Subject: FW: FG/135/17

We refer to the above application by the developer of South Point in Ferring to add an additional dwelling on the site. It was understood that a block of eight flats was approved with a communal garden adjacent to the first bungalow in Beehive Lane.

Proposed Block Site Plan - 1:200 @ A1

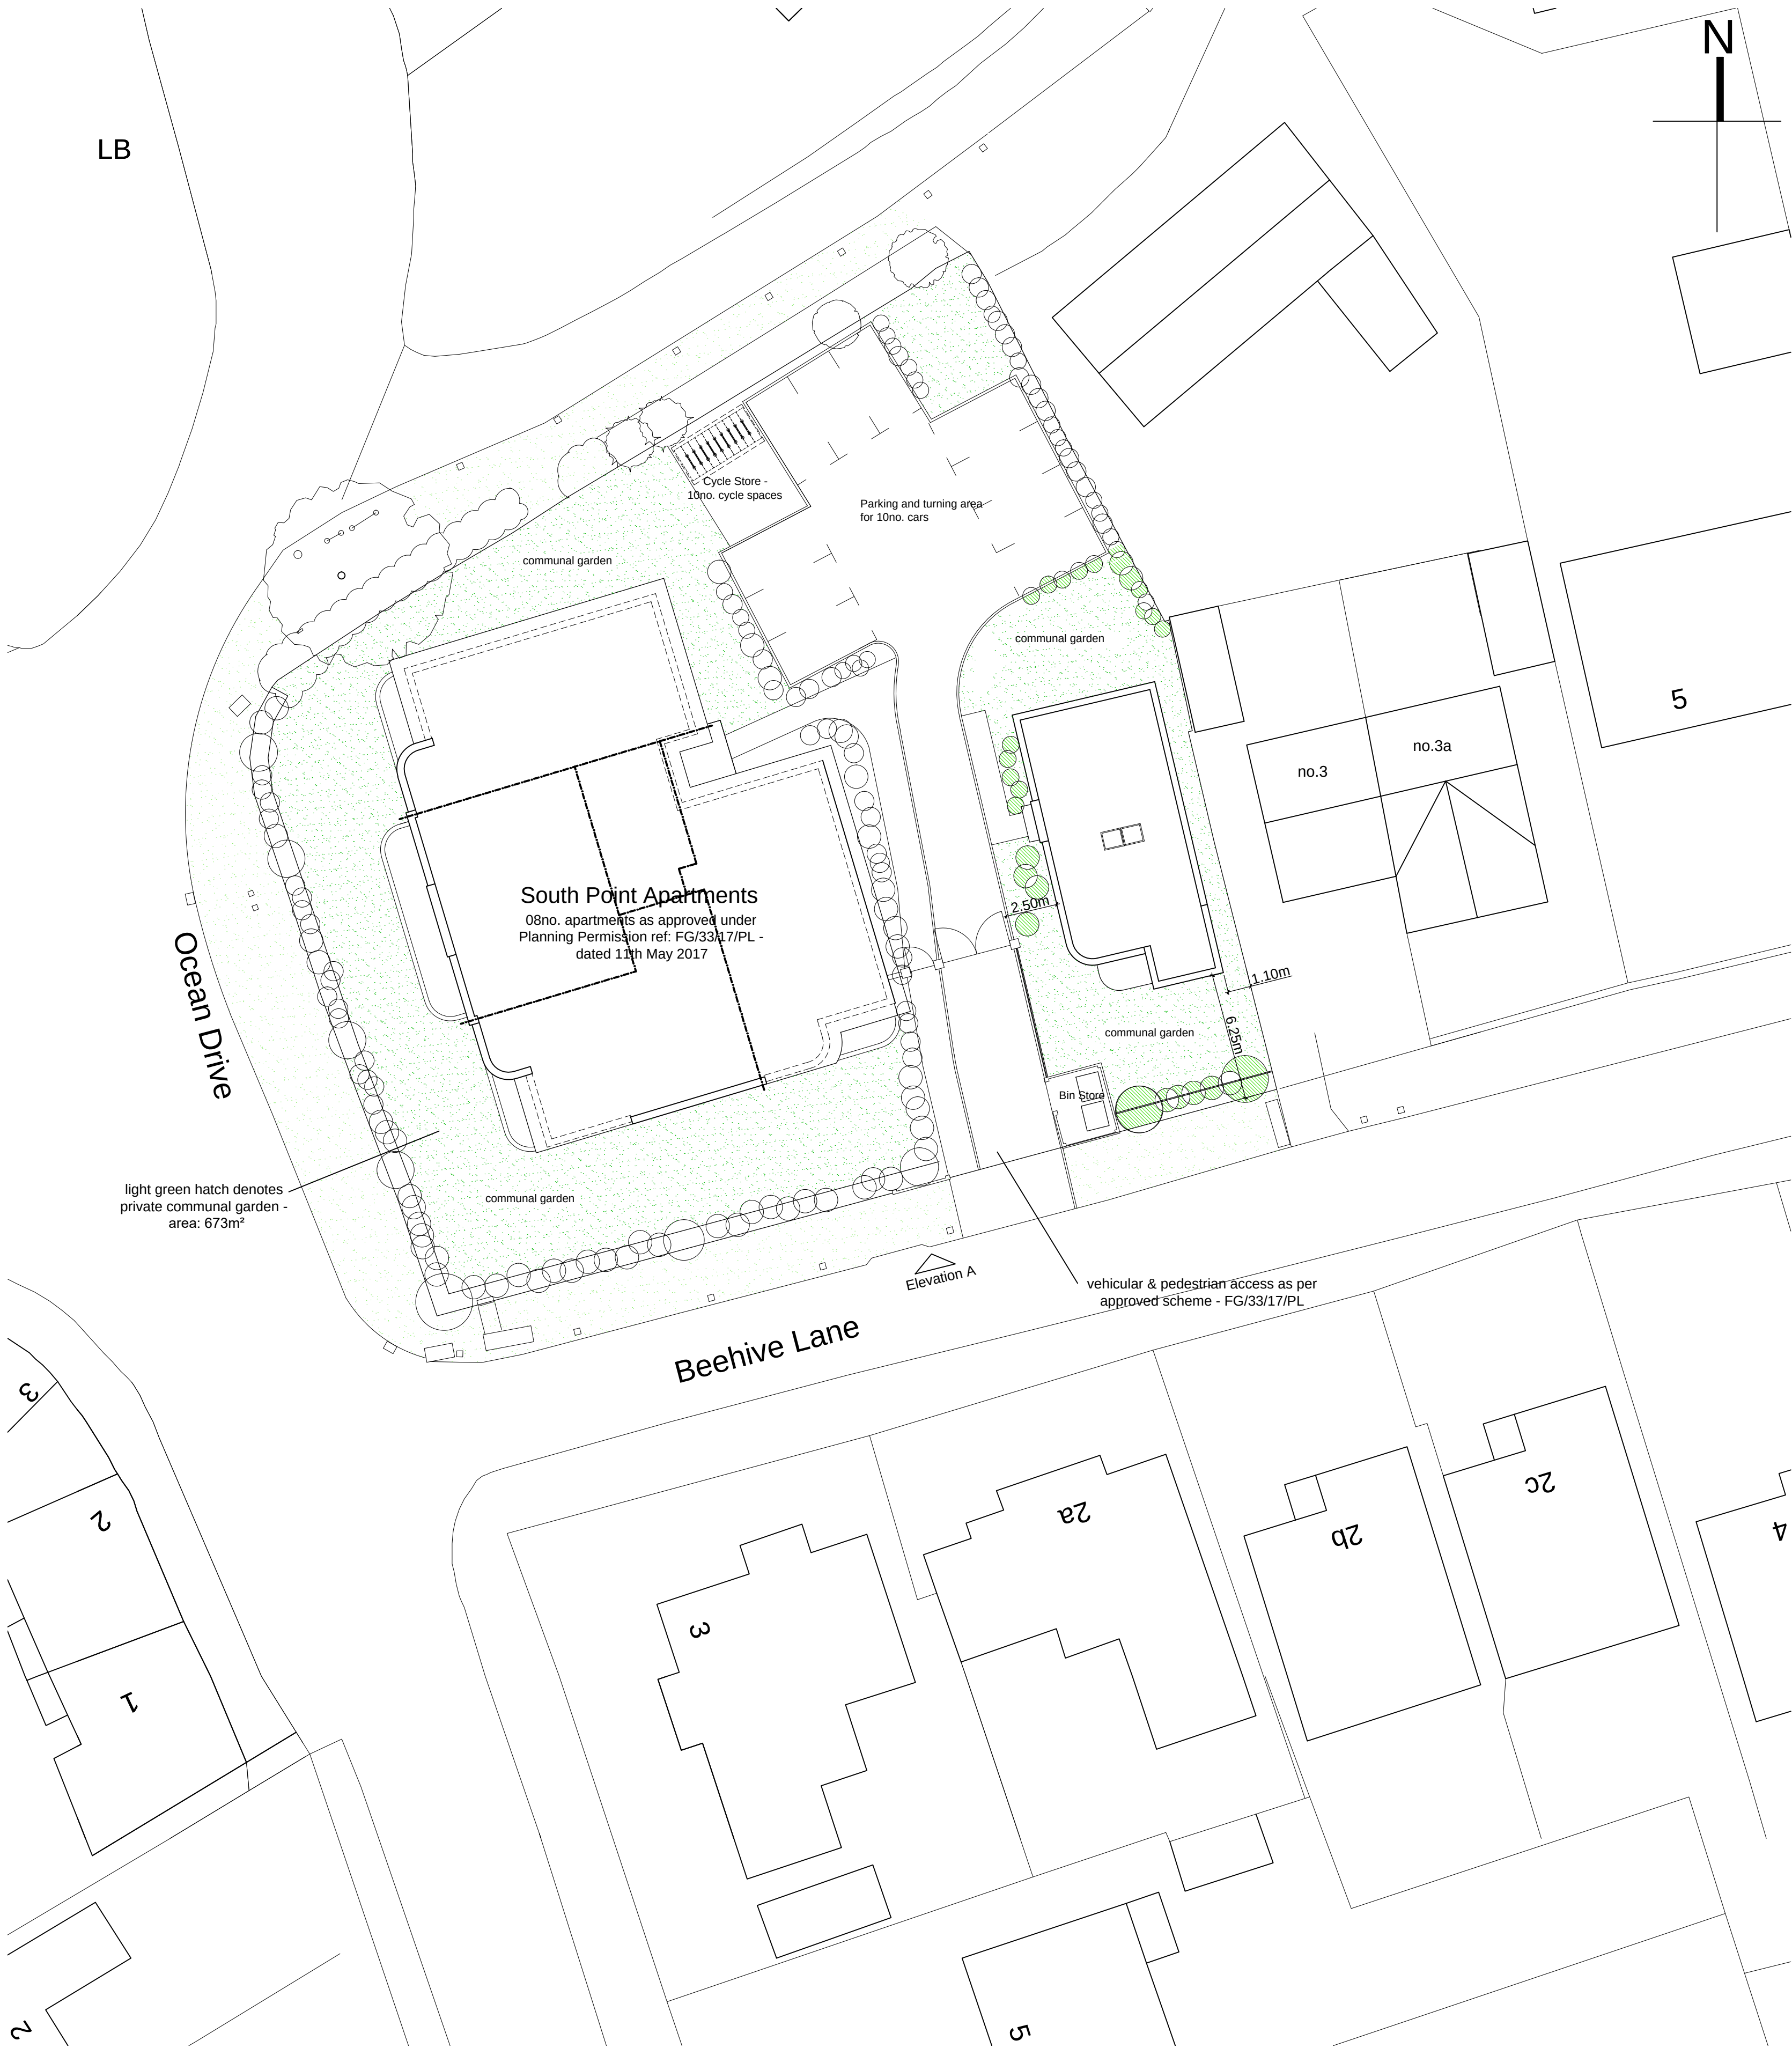
To add an extra dwelling on the site of the planned garden, would be an over development and out of character for the area. It would obviously be too close to the aforementioned bungalow.

We trust , therefore, that this application will be rejected and the developer will be made to adhere to the approved scheme.
